Our Ref: 23/1434/TTPO
Your Ref: 433 - Greenbelt

South Cambridgeshire District Council
Application for Works to Trees Protected by a Tree Preservation Order

Proposal: T1 Ash - Fell reasons as per tree survey believed to have fungus Inonotus hispidus

Site address: 1 Bourneys Manor Close Willingham Cambridgeshire CB24 5GX

Shires Gate

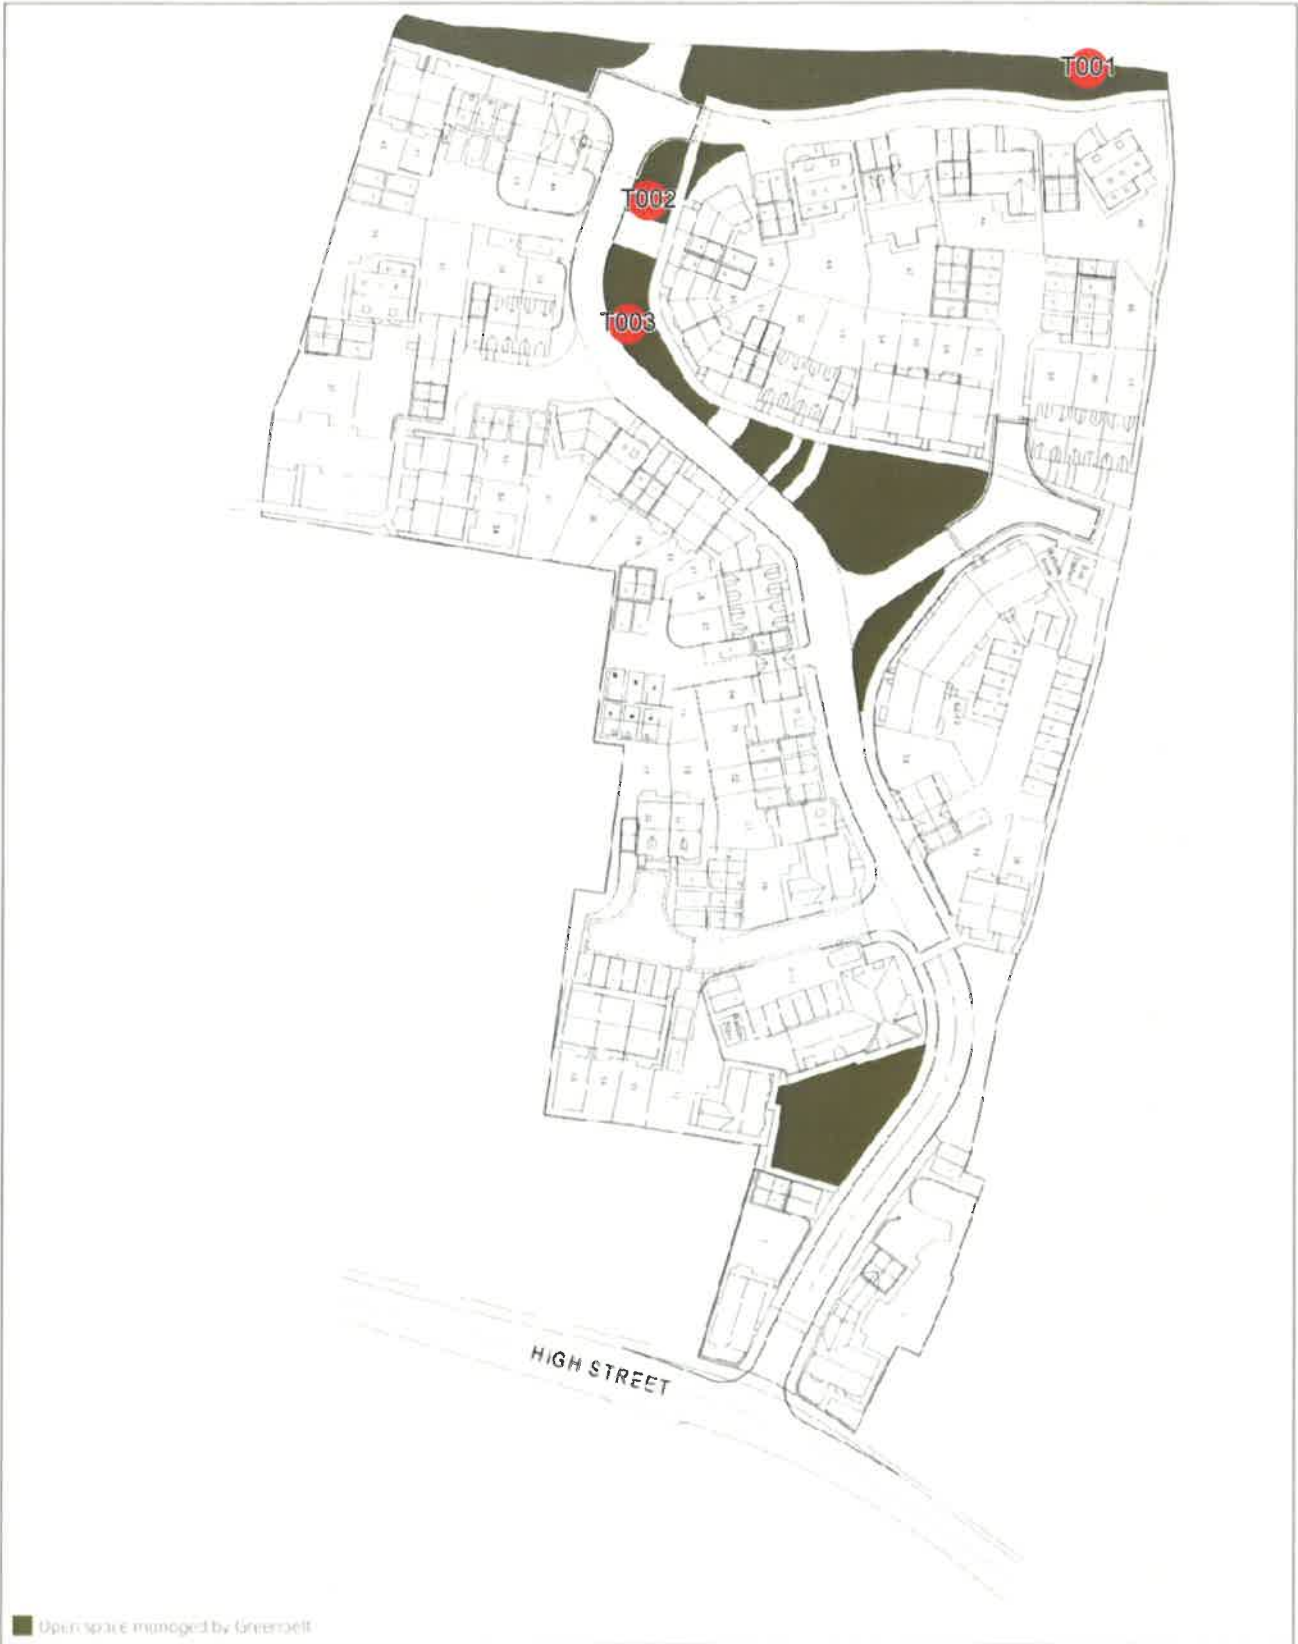
0. The tree location plan is illegible and does not match the location address stated on the application. Please provide a clearer plan.
